# CITY OF ALBUQUERQUE

May 5, 2023

**RE: 1998 Cherokee Rd NW**  
**Grading and Drainage Plan**  
**Engineer's Stamp Date: 04/26/23**  
**Hydrology File: F13D034**

## GRADING & DRAINAGE PLAN

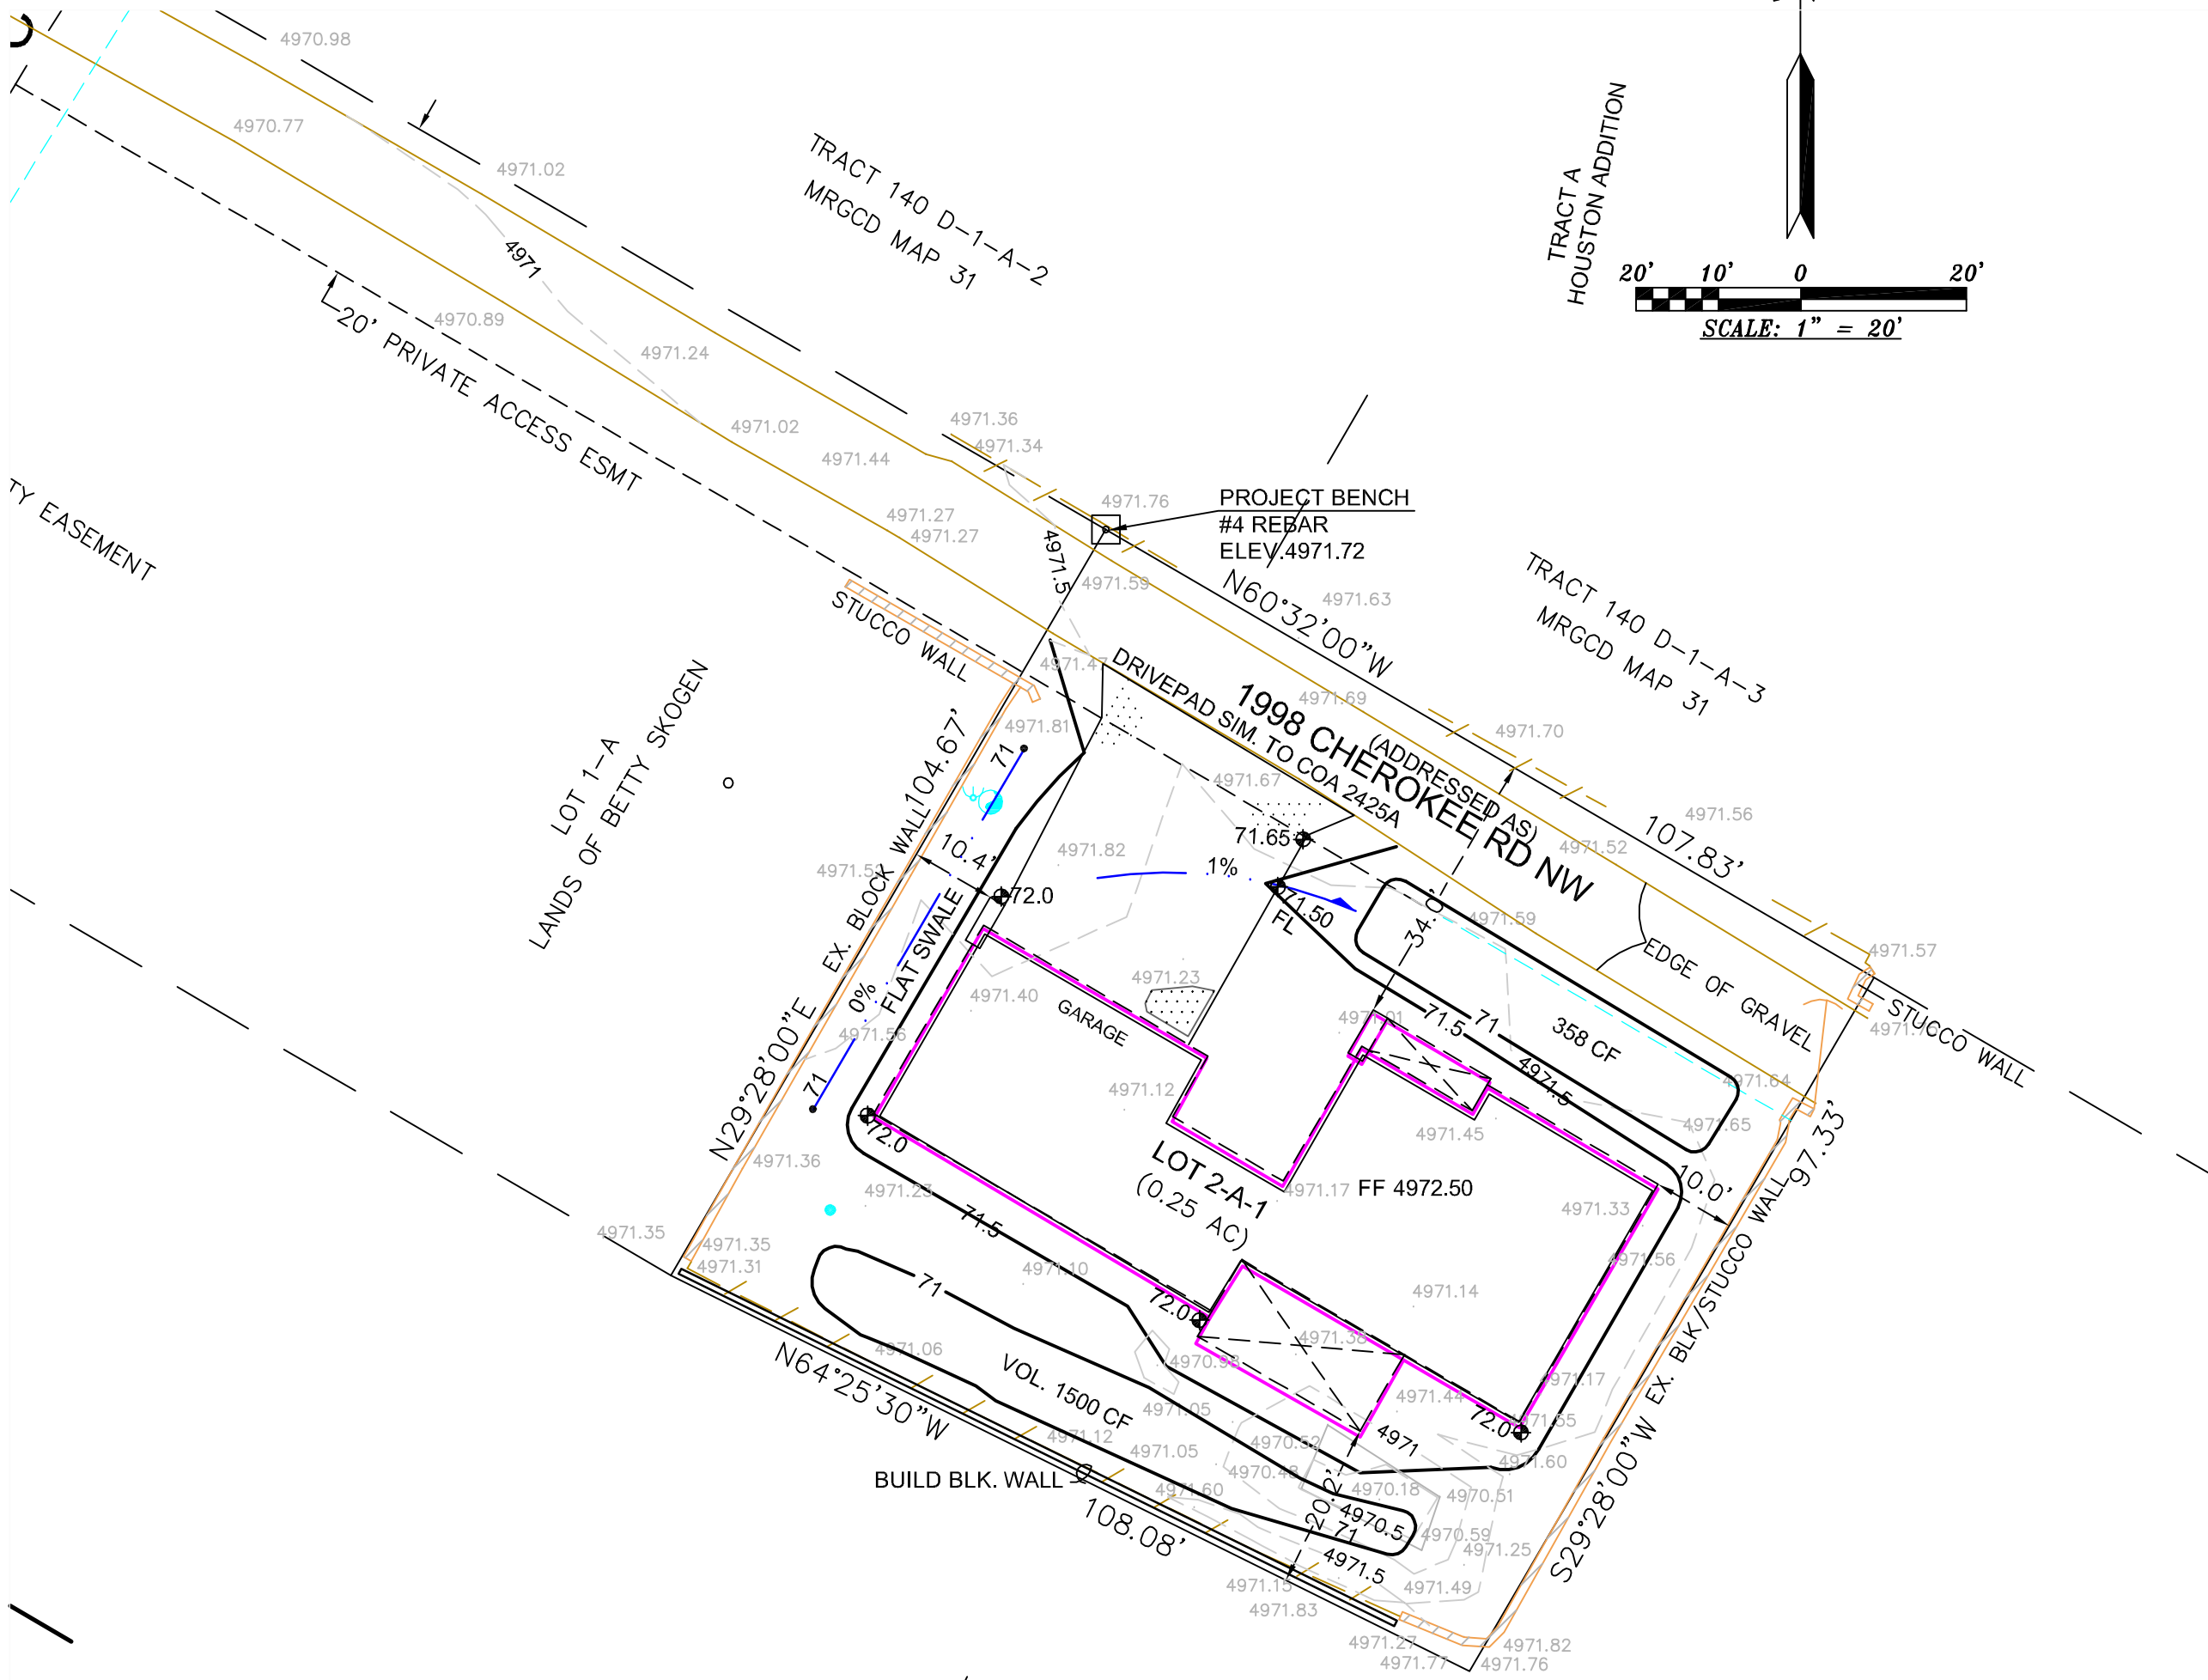
1. As stated, this site follows Article 6-5 Valley Drainage Criteria of the DPM and the required retention volume is 1675 CF. There are two retention ponds shown on the plans. One to the northeast of the proposed house that will provide 358 cubic feet of volume and one to the southwest of the proposed house that will provide 1500 cubic feet of volume. Based on my measurements, the southwest pond has a top of pond area of 628 square feet. With a typical 3 to 1 side slope and a depth of 1 foot, the bottom of pond area is about 148 square feet. The volume that can be obtained in this pond is only about 388 cubic feet. Combined with the first pond, the provided volume is only 746 cubic feet. **This site is short 929 cubic feet of required retention volume.** This may have to be placed in an underground storage system. There are many products on the market that can be used. Please pick one and show that the required retention volume can be provided.
